Application by Springwell Energy Farm Limited for an Order Granting Development Consent for the Springwell Solar Farm

The Examining Authority's written questions and requests for information (ExQ2)

Issued on 2 September 2025

Arable Weed Management Plan

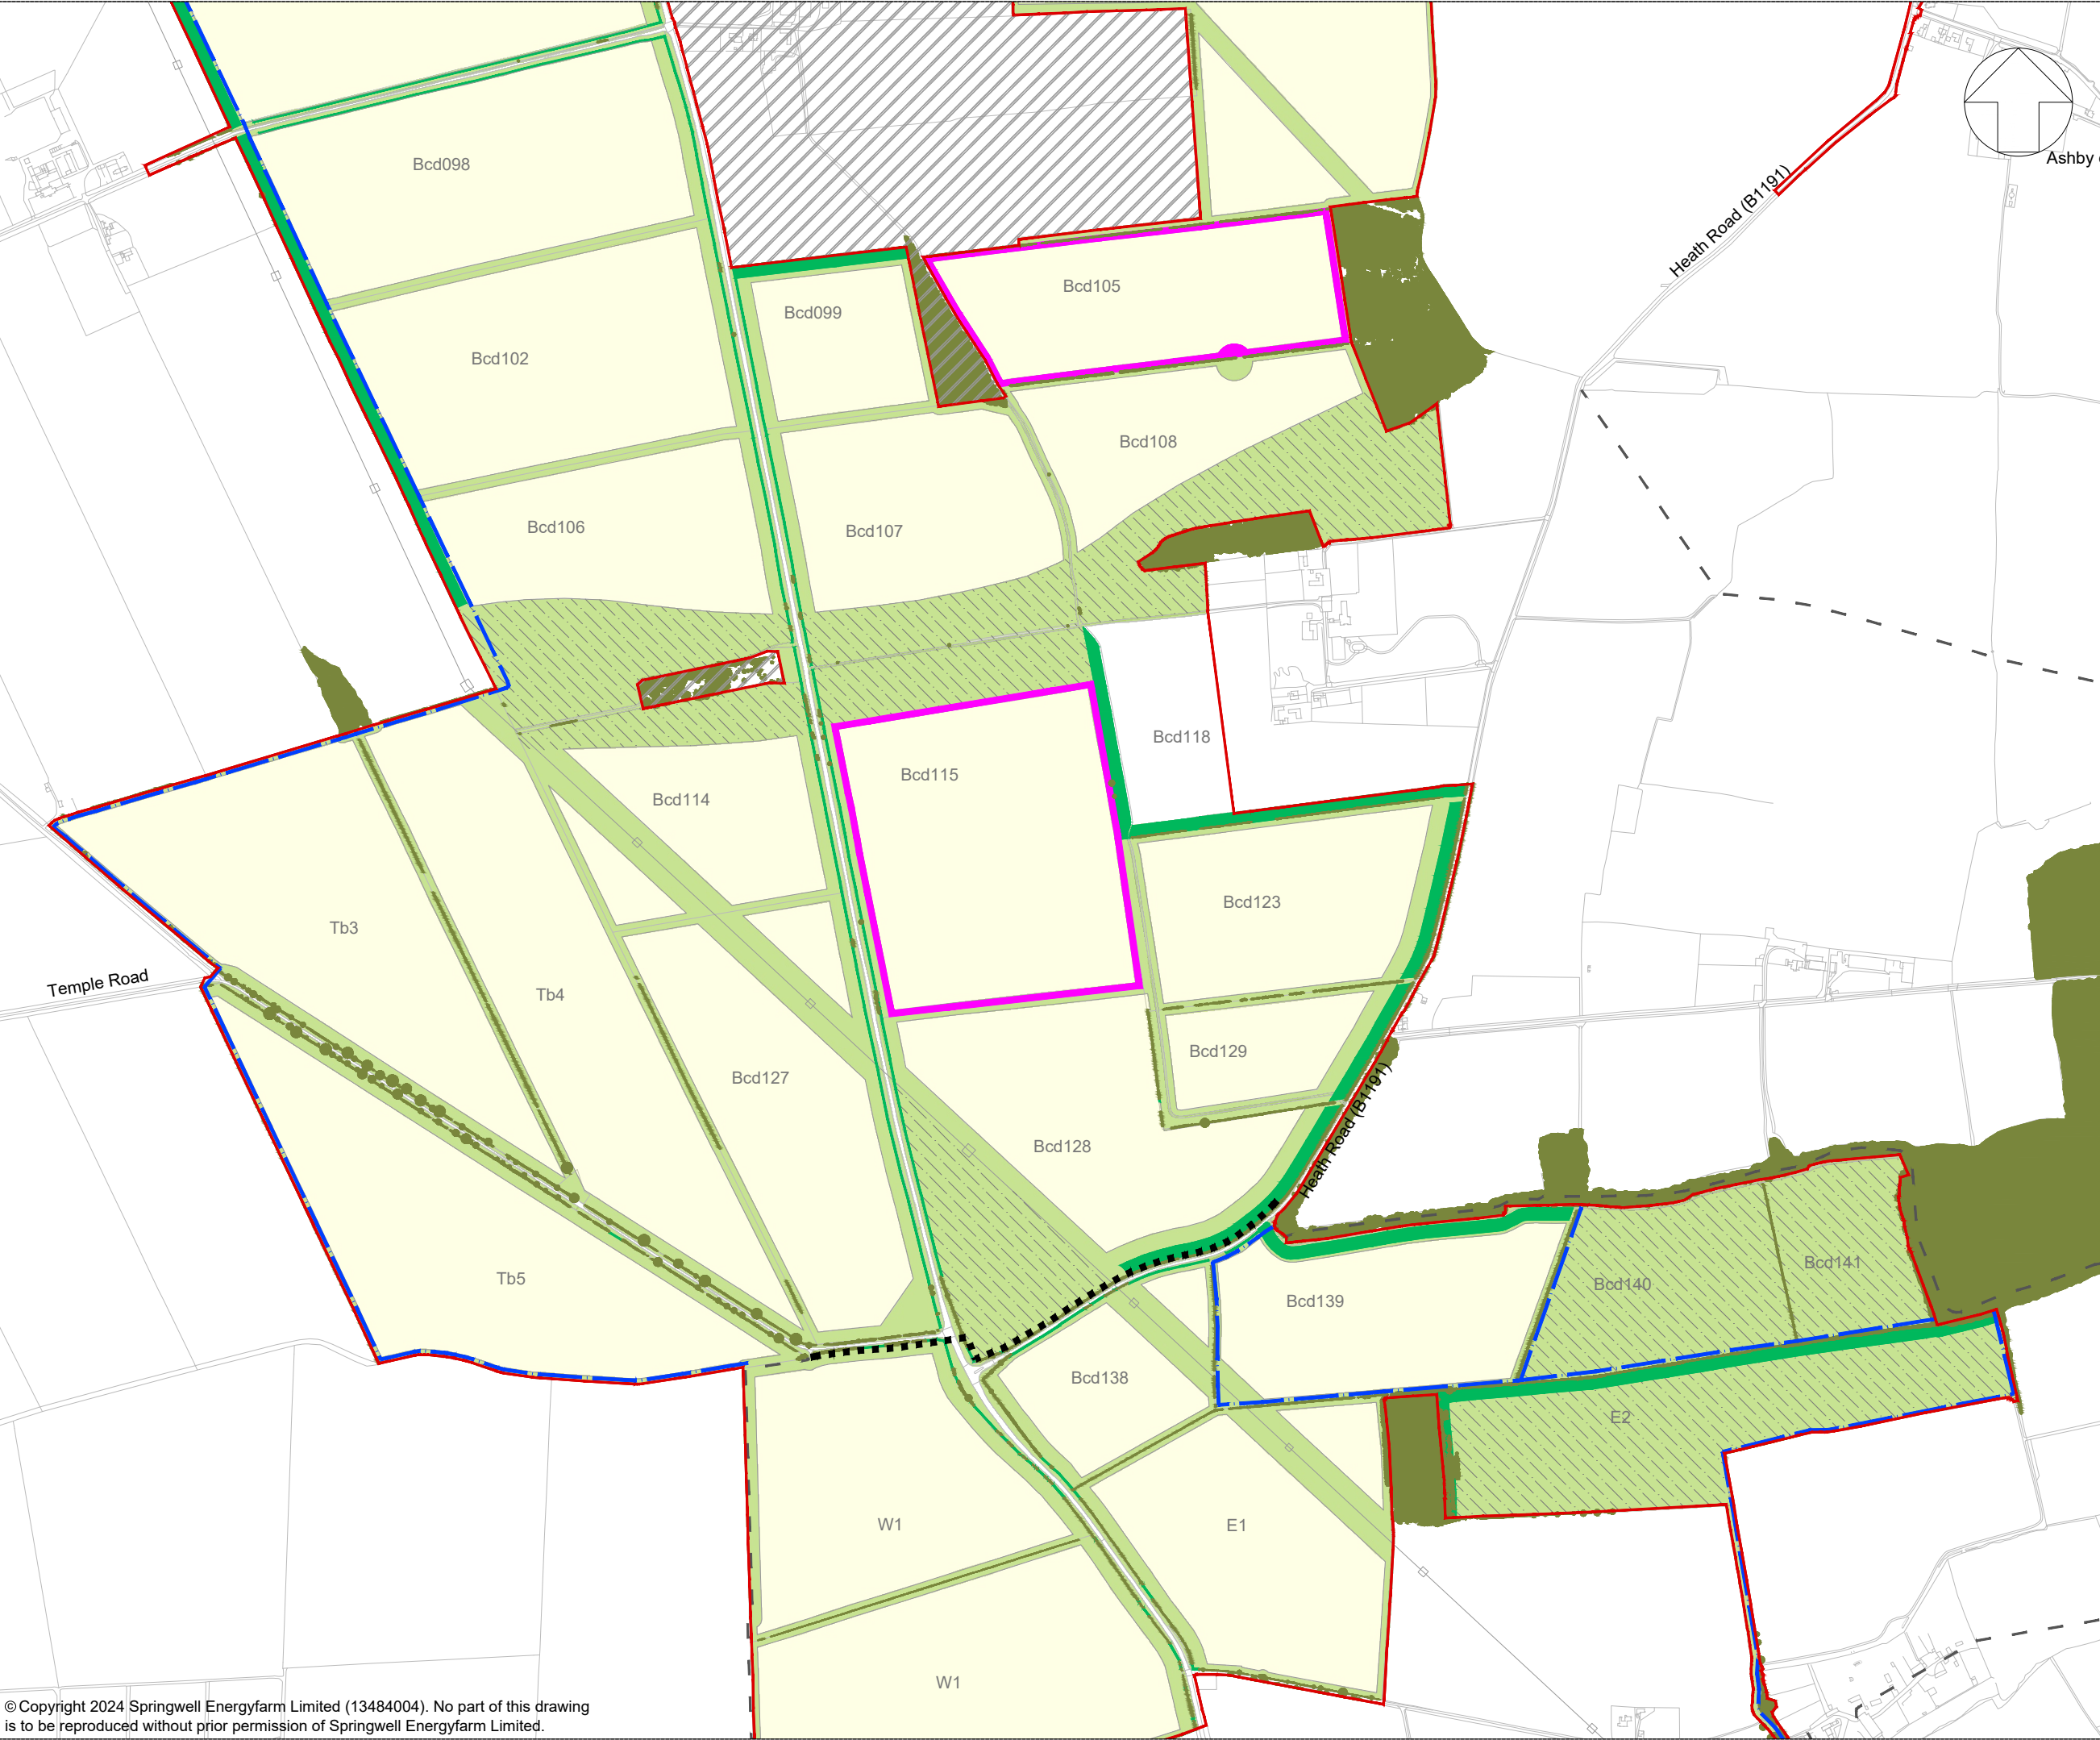
ExQ1	Question to:	Question:
Q2.4.7	Applicant	<p>Scarce Arable Flora</p> <p>In Appendix 5 (arable weed management plan) of the oLEMP [REP3-037], the area of grassland managed to benefit arable weeds does not appear to coincide with target note 9 as shown on the arable survey location figures (Figure 2 of [APP-089]). Confirm whether the area of grassland managed to benefit arable weeds in field Bcd115 shown on the arable weed management plan should extend to the north-east corner of the field to include target note location 9.</p>
